To: FILE
From: Jean Fraser
Subject: Application ID: 2015-085
Date: 9/2/2015

To: Jean Fraser
Barbara Barhydt
From: David Margolis-Pineo
Re: 81 Industrial Way – New Office Complex (2015-085)

The Department of Public Services has the following final development review comments.

SHEET 3 OF 7

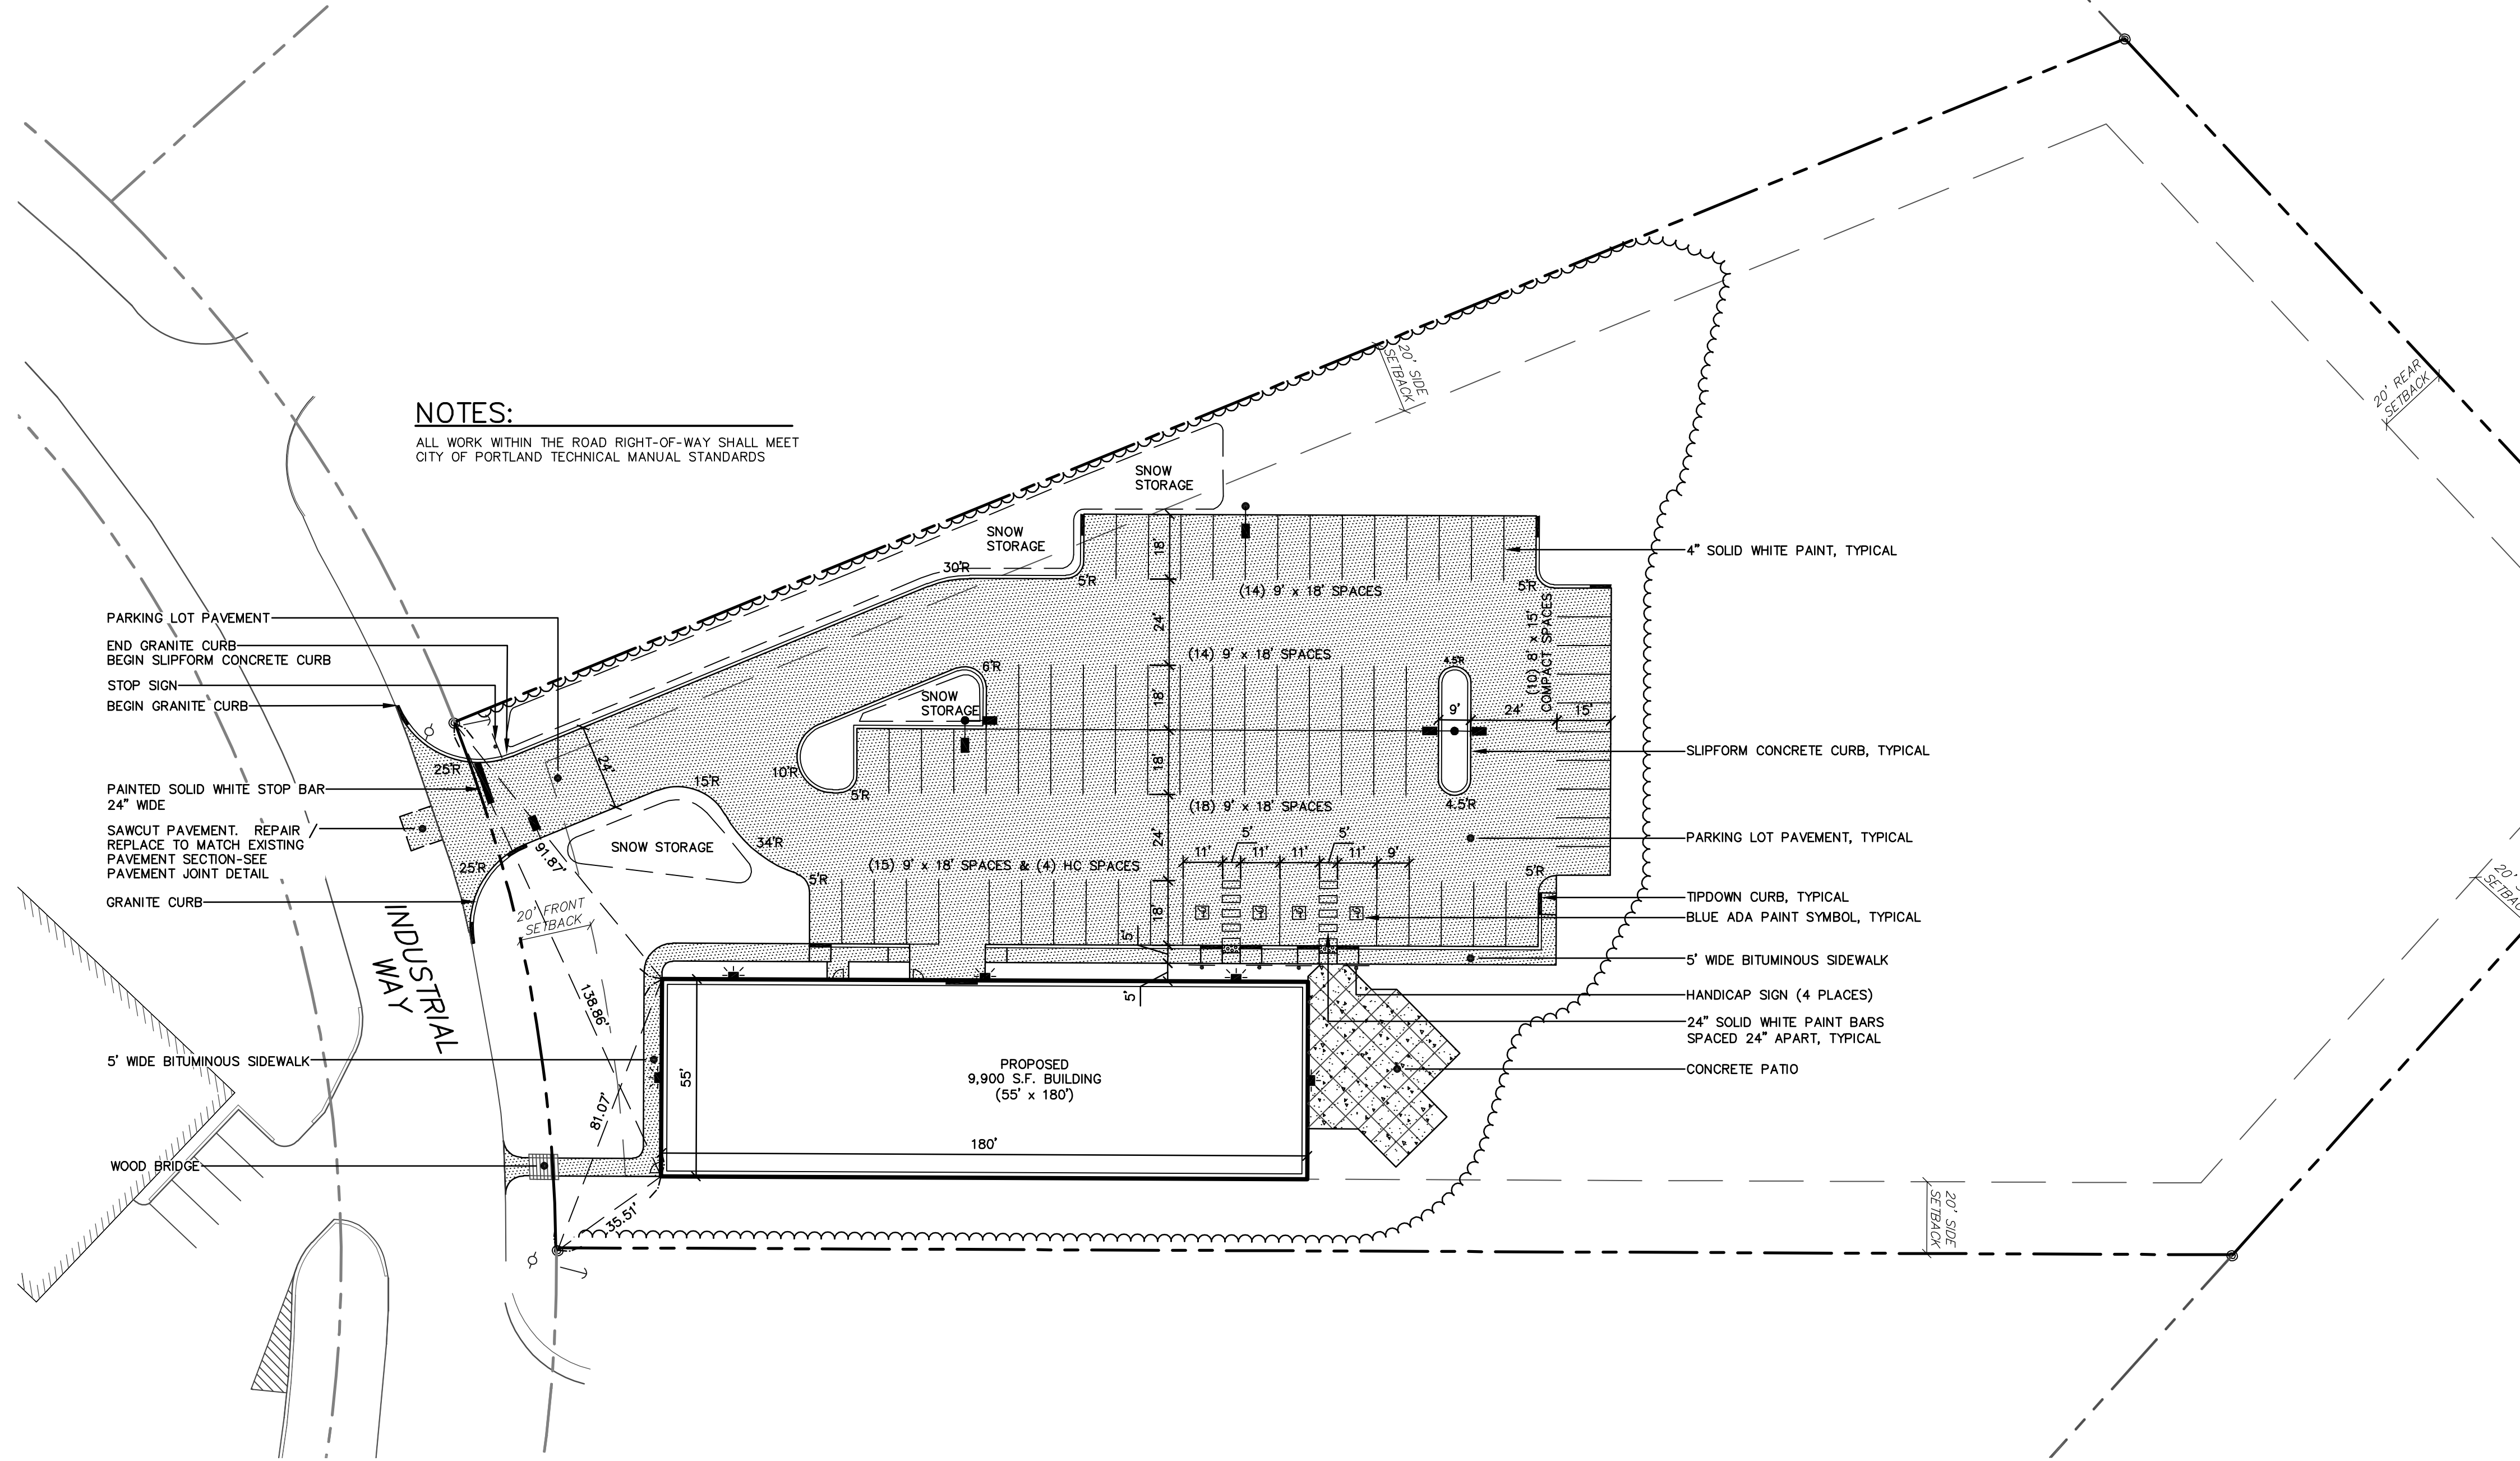
1. All plans require a professional stamp.
-Plans have now been stamped.
2. Please add note stating that all work within the road right of way shall meet City of Portland Technical Manual standards.
-Note has been added.

4. It appears that radius granite curbing is proposed for the drive cut consistent with the other drive cuts in this park. Please verify that in fact that is the intent.
-Applicant has provided information to satisfy this comment.

PROJECT NO. 04479
SCALE NTS
SHEET 7 OF 7
044790.dwg 148.02

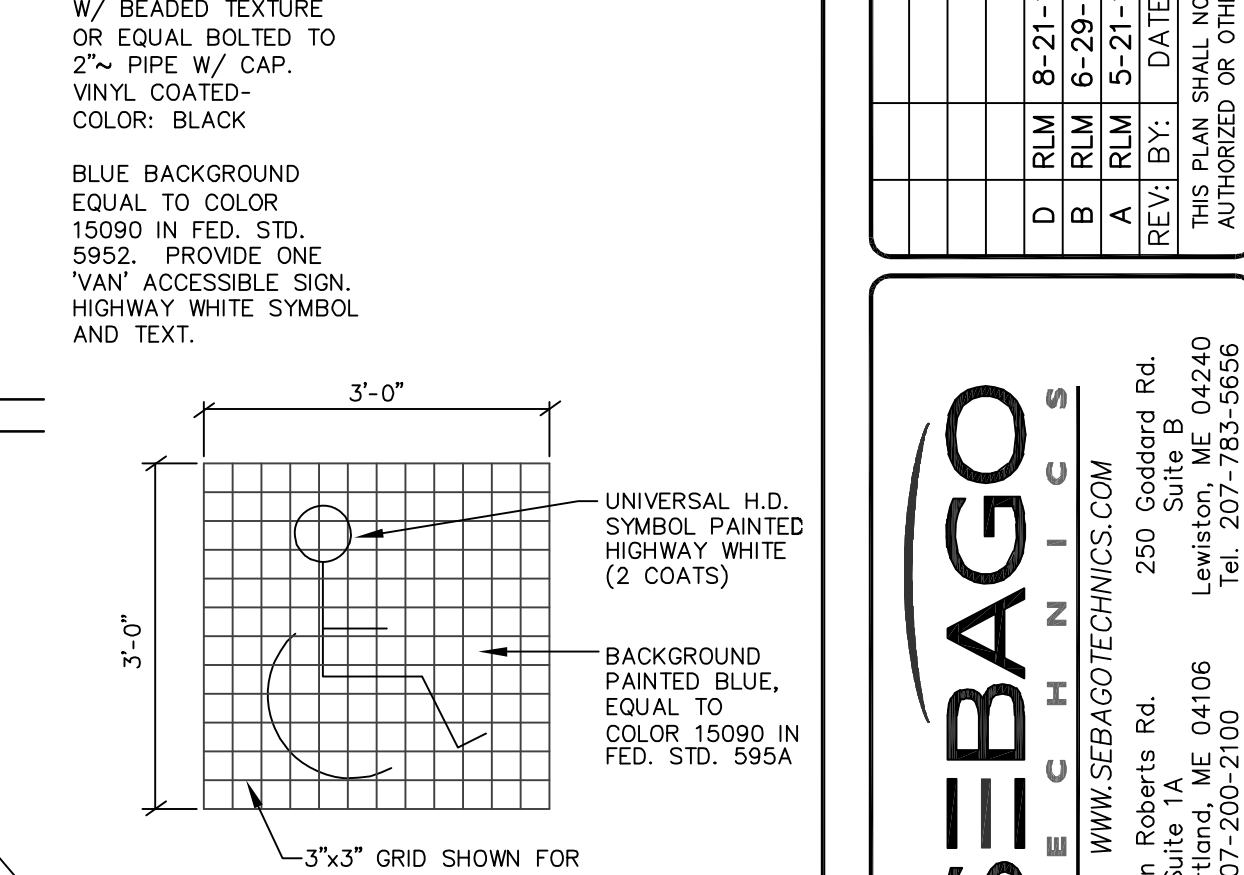
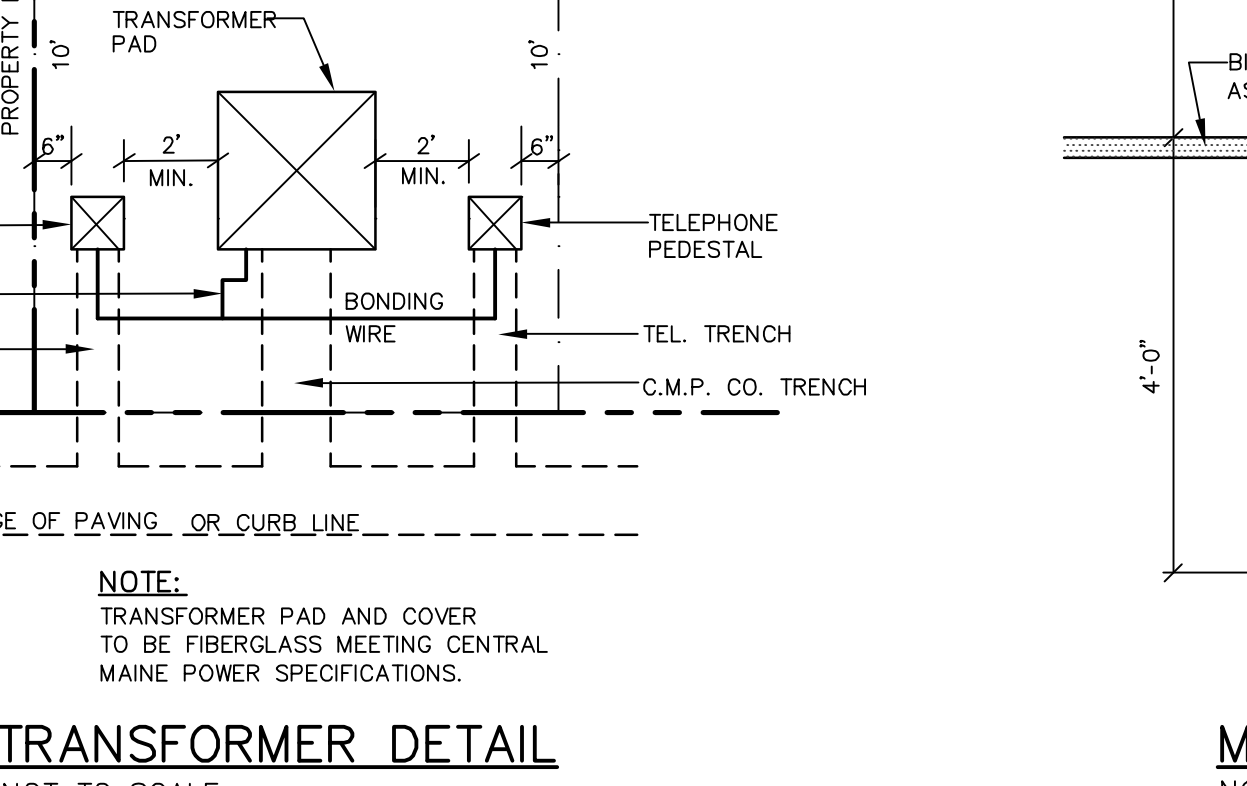
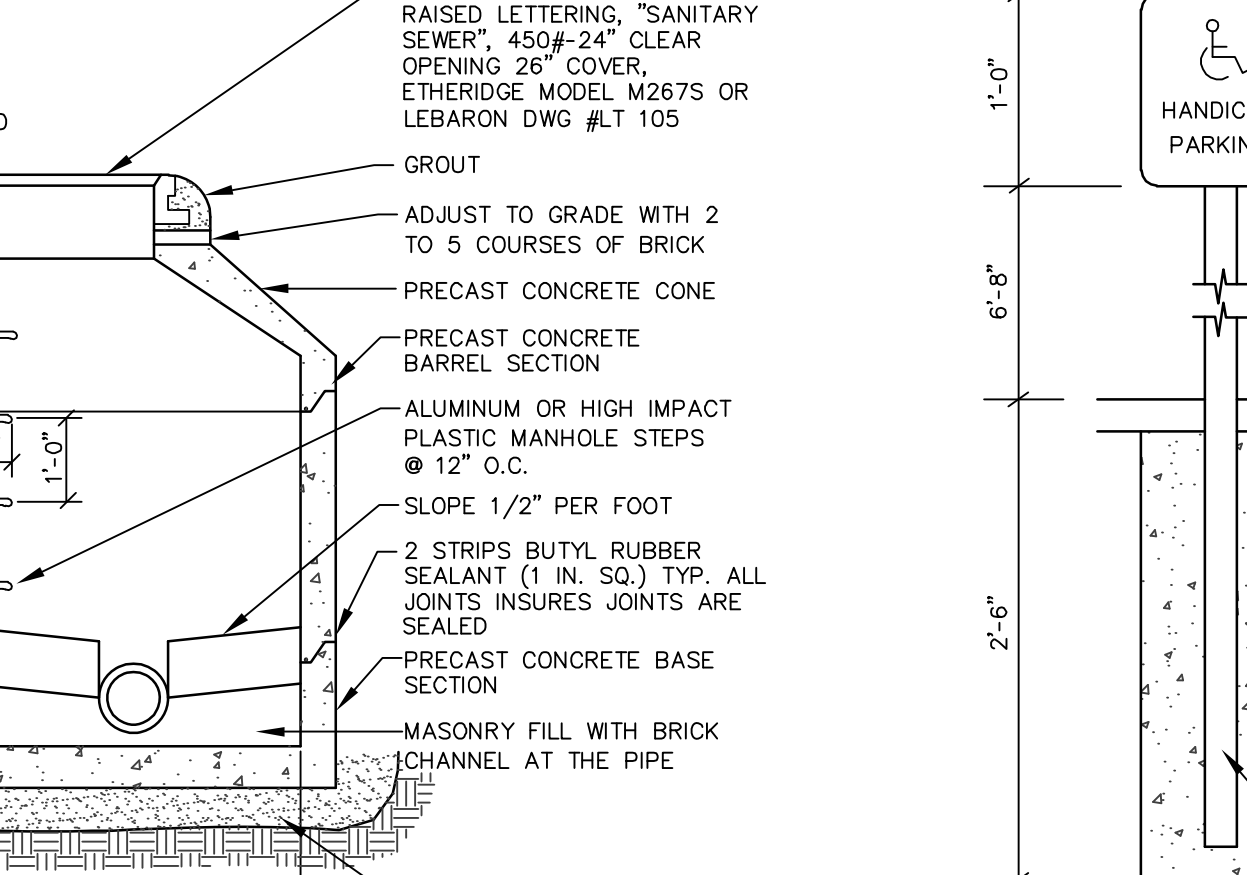
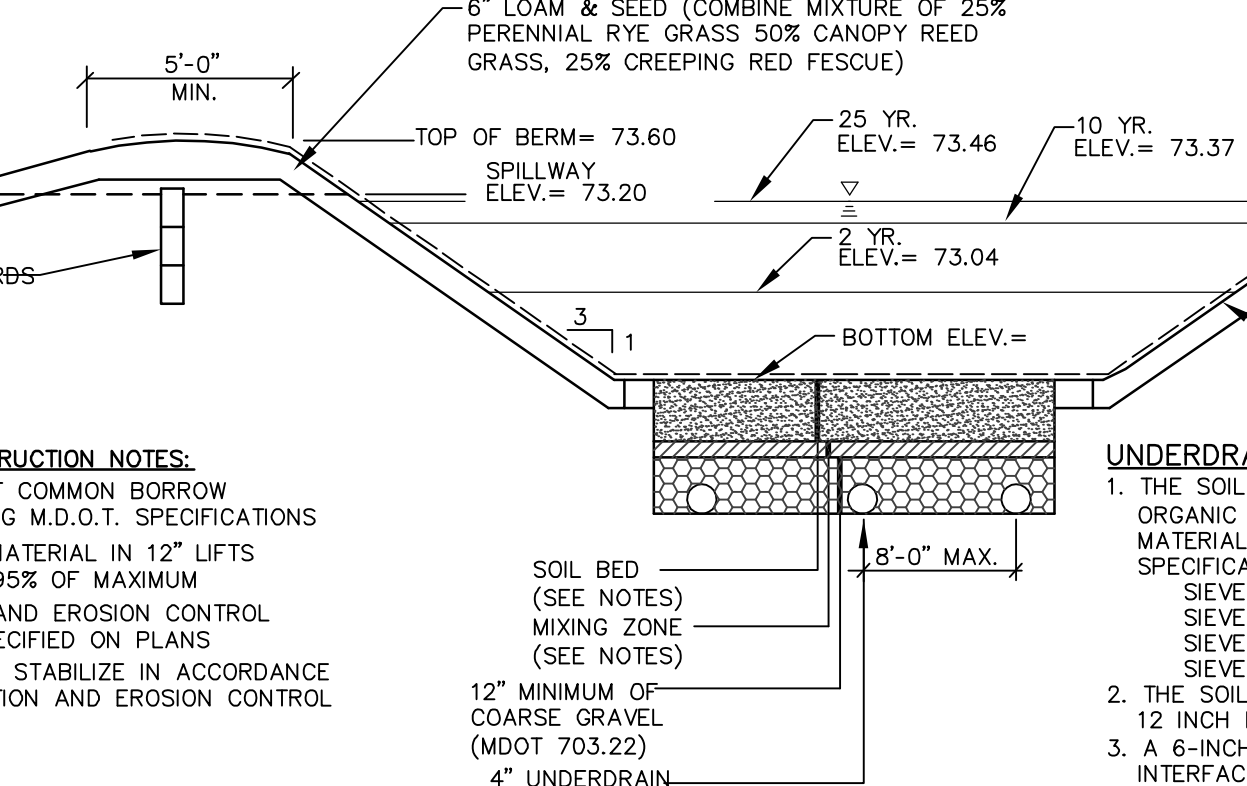
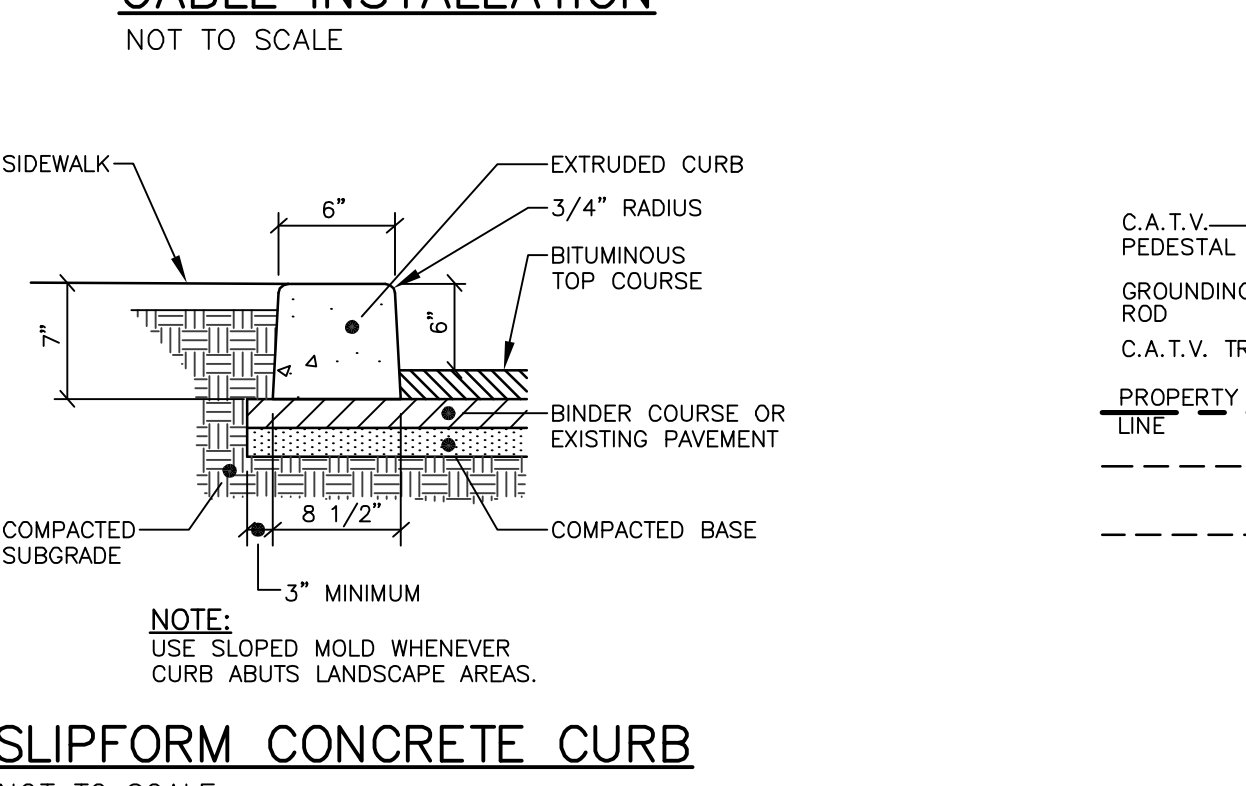
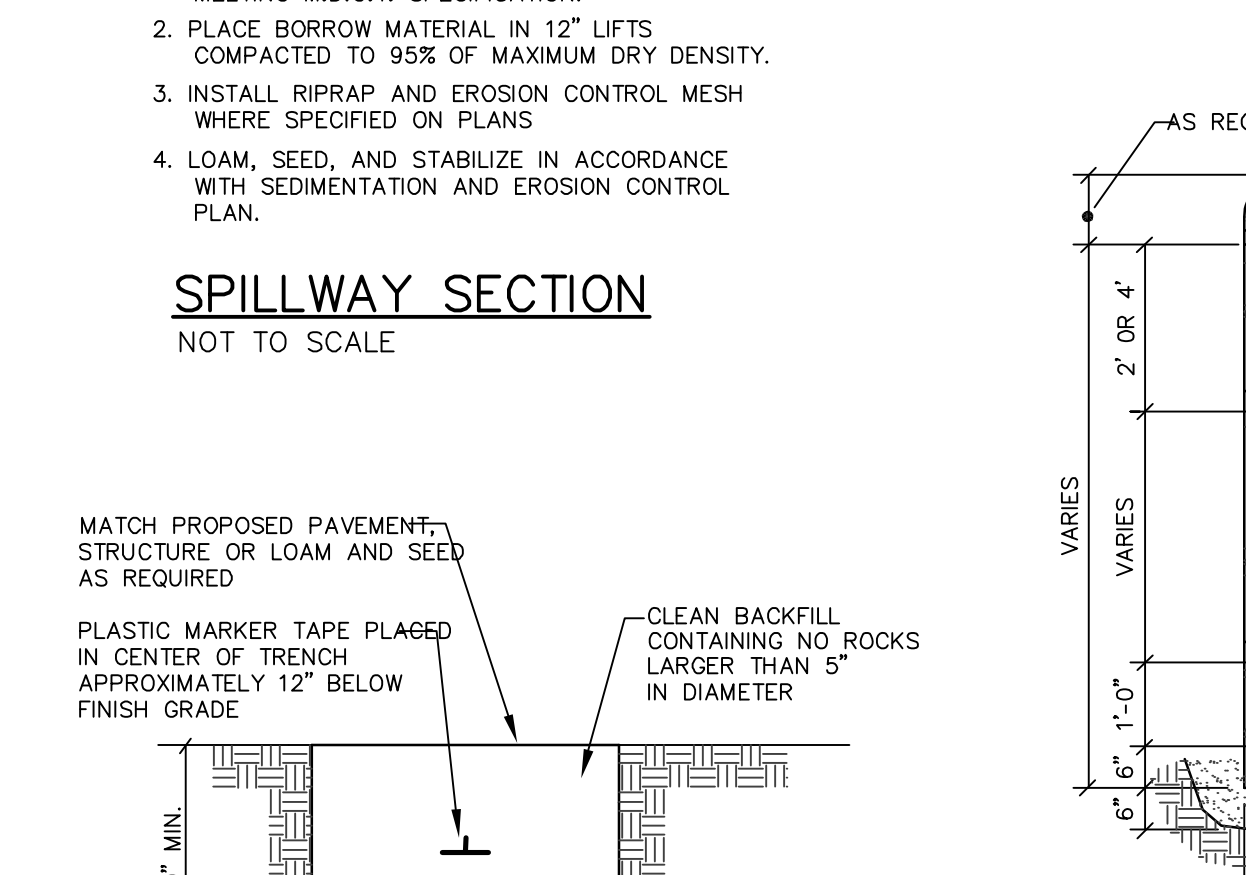
3. Provide detail of 6" sewer connection in Industrial Way showing manhole penetration, and shelf and channel configuration.
-Applicant has provided information to satisfy this comment.
